ROMENS SUBDIVISION ZONE CHANGE EXHIBIT

SECTION 24, TWP 11, RANGE 64 WEST OF 6TH PRINCIPLE MERIDIAN
EL PASO COUNTY, COLORADO

PCB FILE NO: P-##-###

## ZONE CHANGE EXHIBIT

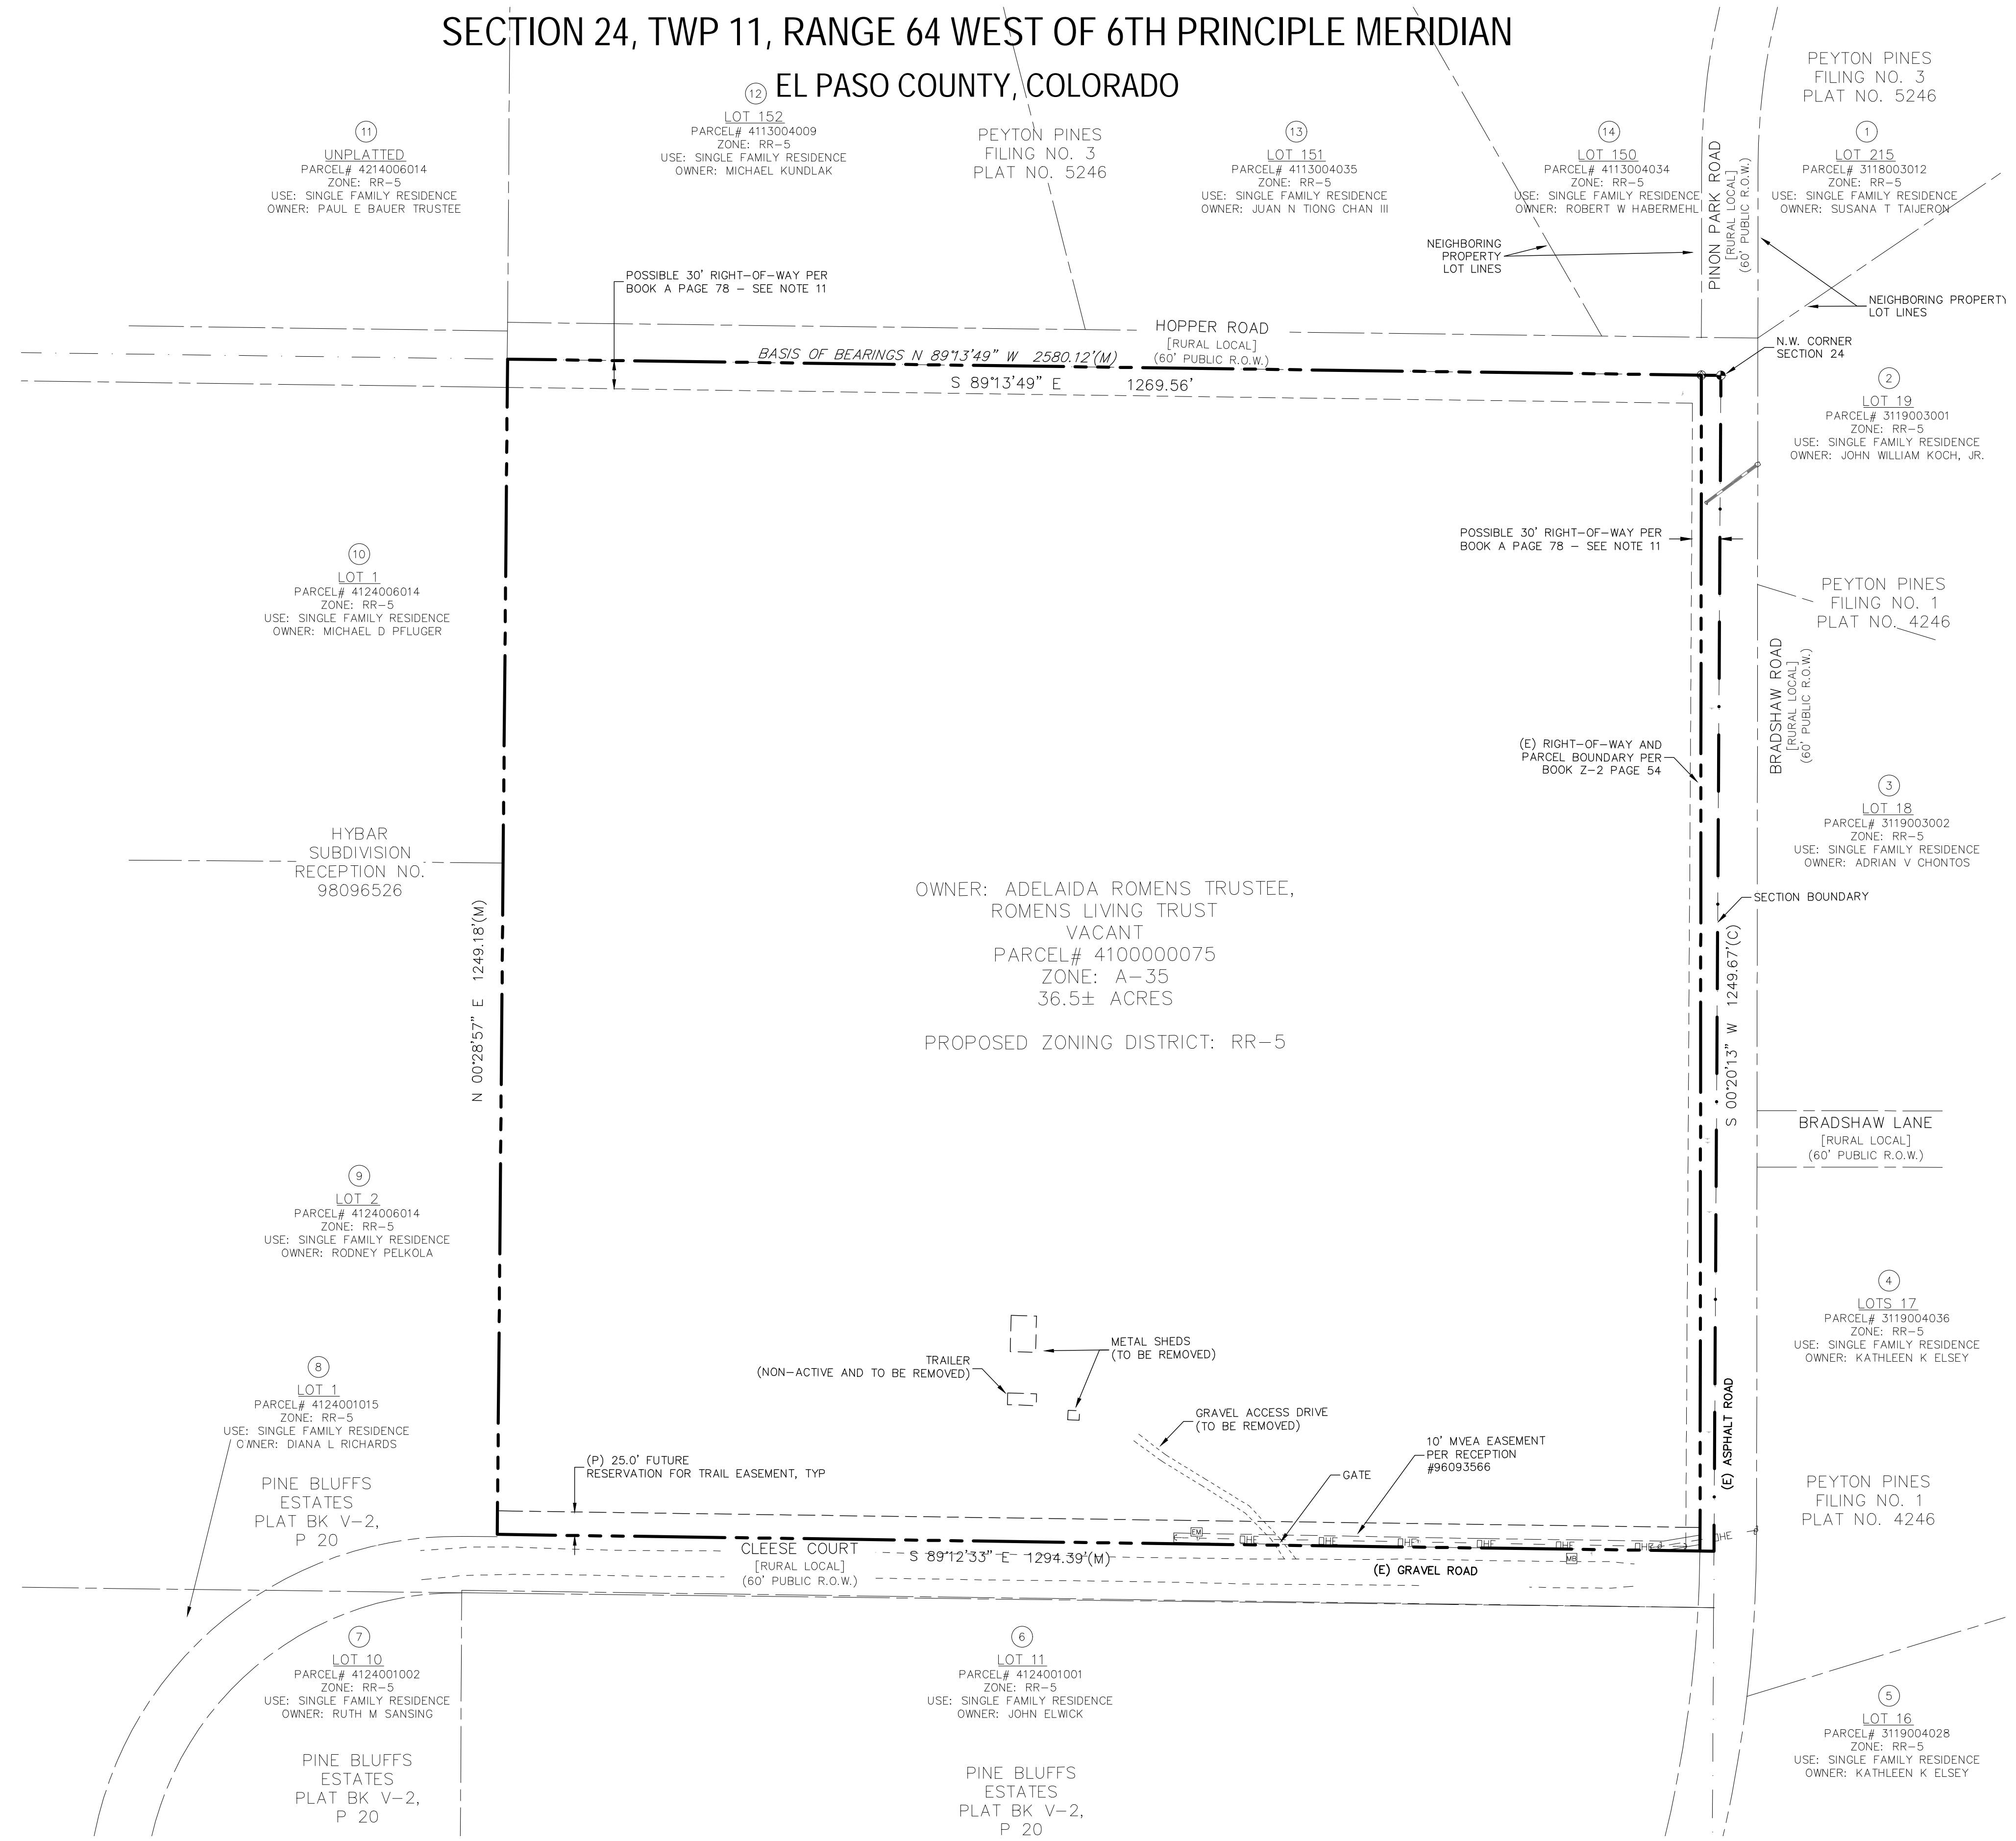
Please include the parcel number for quick and easy reference under the information of each lot, including the one under review.

MVEA has ownership in this property? please explain and illustrate

This line type is not represented on the legend, please specify what this line is representing.

This line type and width is not represented anywhere on the plan, please amend.

What 10' easement is this representing? please label

Please show the MVEA required easements.

It is unclear what these lines represent. Please label.

Is Bradshaw rd occupying the property? Show the road dedication.

This line type is not in the legend, please update

This easement line does not have another side, label or width - please amend.

LOI indicates 34.47 acres after road dedication.

Are these existing structures? if so, please include. Is the mobile home an active residence? if so, this is not a vacant lot.

label please - easement? Driveway?
